Consultation Response from: KC Environmental Health (Pollution & Noise Control)
2021/91537 - Dearne Grange Farm, Park Head Lane, Birds Edge, Huddersfield, HD8 8YA
Discharge conditions 3, 4, 14, 16 on previous permission 2020/91484 for demolition of stable block and erection of detached dwelling
Date Responded:
23rd June 2021
Responding Officer:
Natalie Heaney
Responding Ref:
WK/202113595

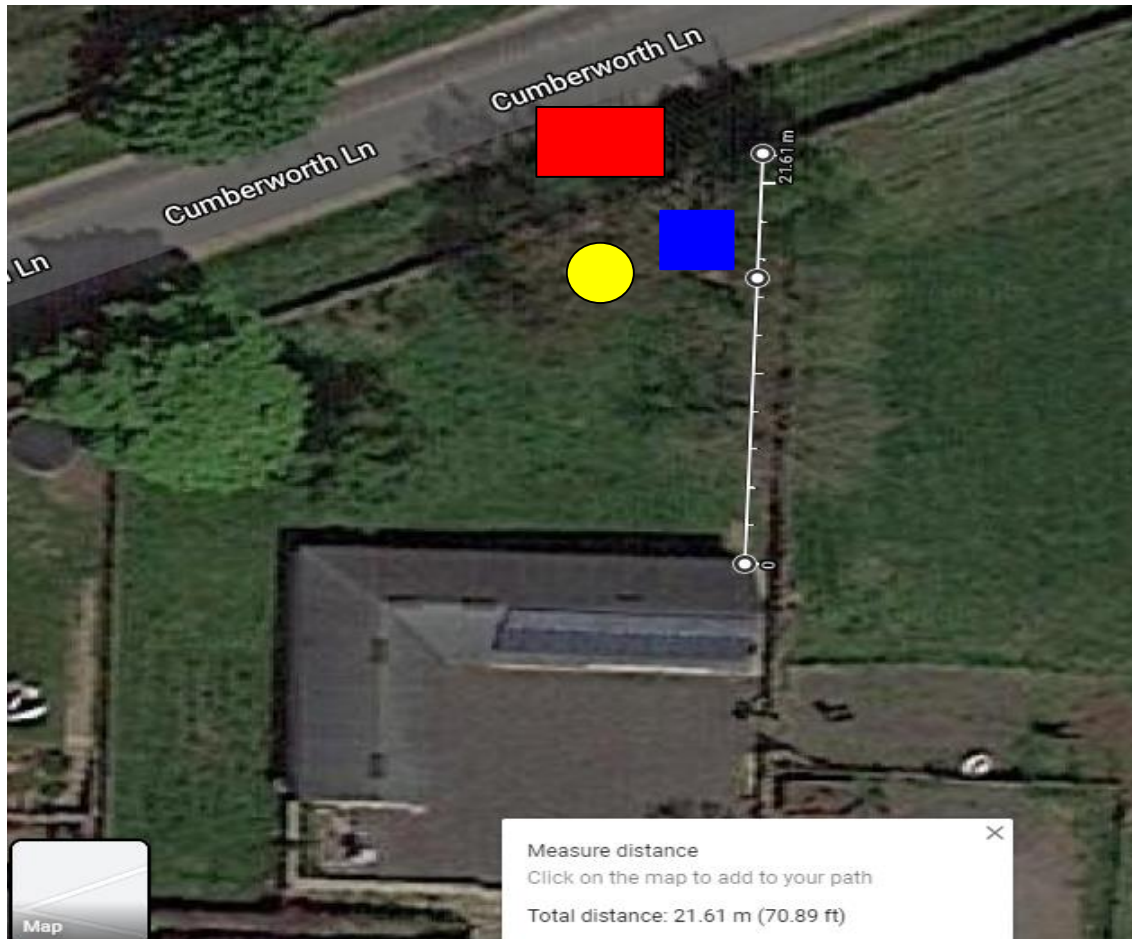
The location of the treatment plant shown on the drainage plan submitted in support of Condition 14, is deemed to be in a suitable location and has been cited to avoid nuisance to nearby properties. The remaining information submitted in support of this condition is outside the remit of Environmental Health.
